**17 September 2015**

**REDEVELOPMENT OF FOUR POINTS by SHERATON HOTEL at 161 SUSSEX STREET**

**NEW ROOFTOP BAR AND LOUNGE**

**RESPONSE TO OBJECTIONS RECEIVED RELATING TO DEVELOPMENT APPLICATION ACOUSTIC REPORT**

**Figure 3:** Surroundings with land uses and distances to closest sensitive receivers and Executive Lounge and Bar footprint (purple shadow)

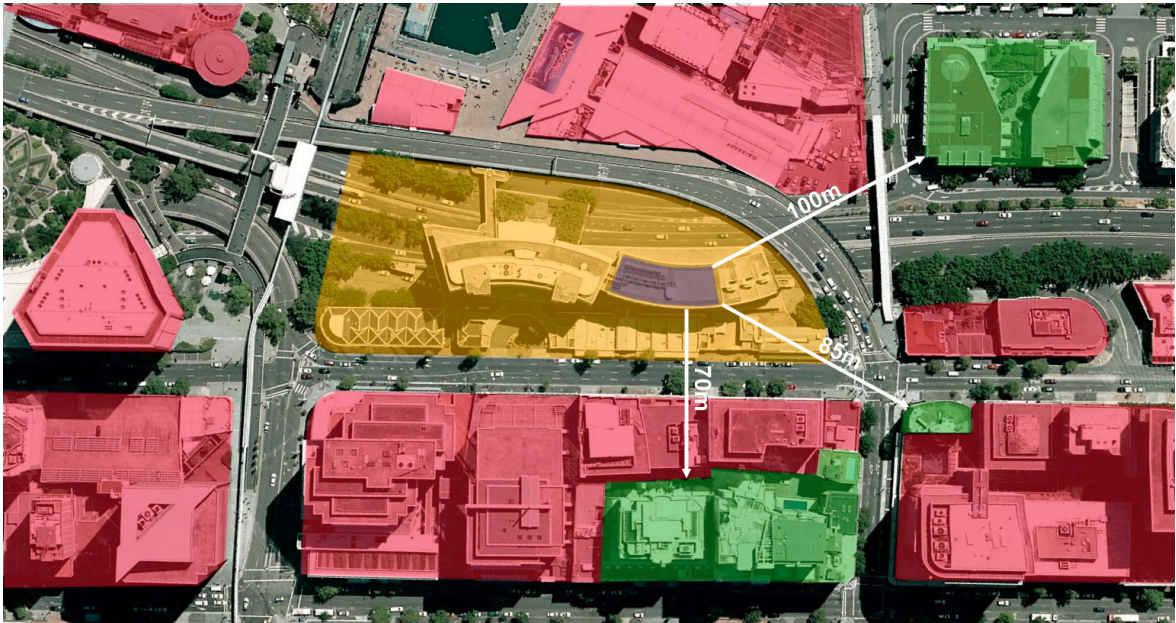
However, this is not true as there is a direct line-of-sight from the upper levels of our clients' site to the Level 12 Bar should the Louvres be open. Furthermore, the assessment does not take into consideration redirections, reflections or reverberation of sound due to the ongoing operation of the Level 12 Bar, especially in a 24 hour format.

The comment in the acoustic report regarding screening of this receiver relates to the closest receivers at this address (ie those receivers at approximately 70 m distance from the proposed bar and lounge - refer to Fig.3 in report). We acknowledge that there may be either full or partial line of site from the residences on the upper levels of this receiver to part of the terrace (western-most part). However, the distance to these receivers will be greater than 70 m, and the number of 'unscreened patrons' will be less than that assumed in the assessment (due to the reduced area of unscreened external bar terrace area). Given this, the predicted noise levels at all receivers at this address are expected to comply with the relevant noise criteria and limits.

We also note that, in determining the noise levels at all affected receivers, appropriate allowances have been made for building screening or attenuation, distance attenuation and sound reflections off surrounding buildings and structures.
